**TOWN AND COUNTRY PLANNING SCOTLAND ACT 1997  
USE OF FLAT FOR SHORT-TERM LET USE (SUI GENERIS) AND RESIDENTIAL  
FLAT (IN RETROSPECT). AT 2F2 9 RAEBURN PLACE, EDINBURGH, EH4 1HU  
REFERENCE NUMBER: 24/00954/FULSTL**

**INCOMPLETE APPLICATION**

**Planning Application No: 24/00954/FULSTL  
Scottish Government No: 100648874-002**

9/4, Raeburn Place, Edinburgh, EH4 1HU

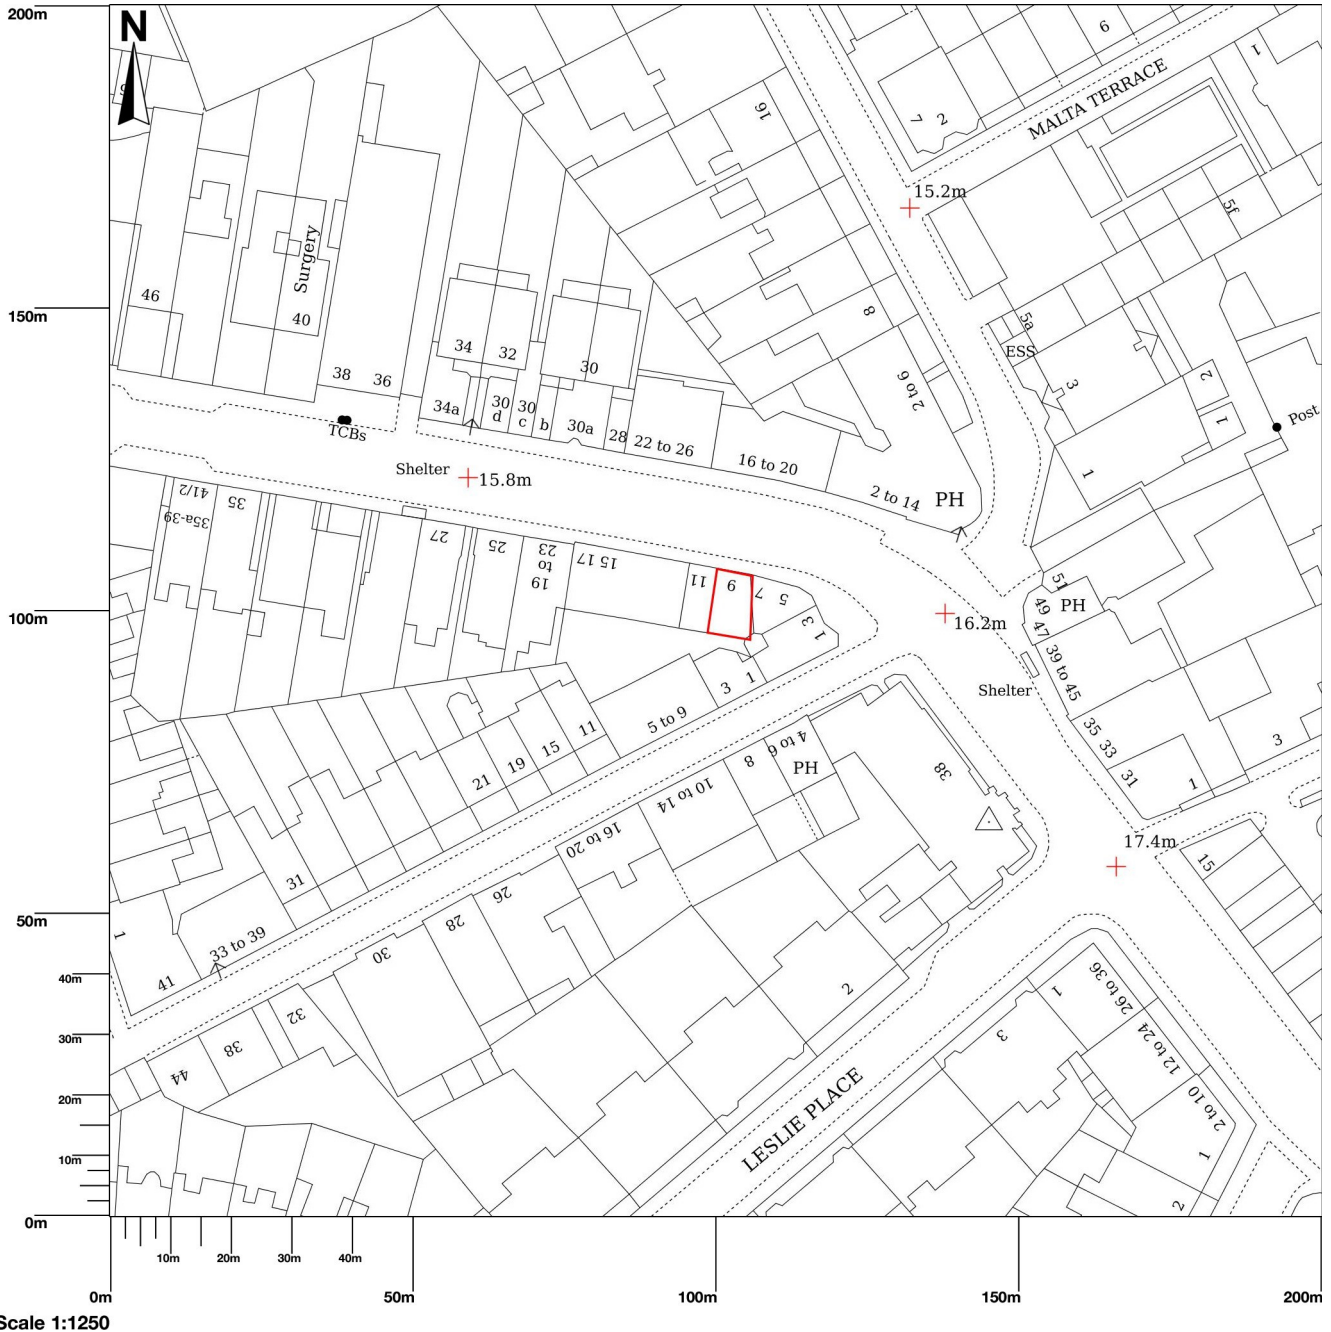
**01. Amended location plan required - at scale 1:1250 or 1:2500 for larger sites. The application site boundary must be accurately outlined in RED and match the size and position of the floor plan. From the floor plan it looks like the flat sits above No 1 Raeburn Place.**
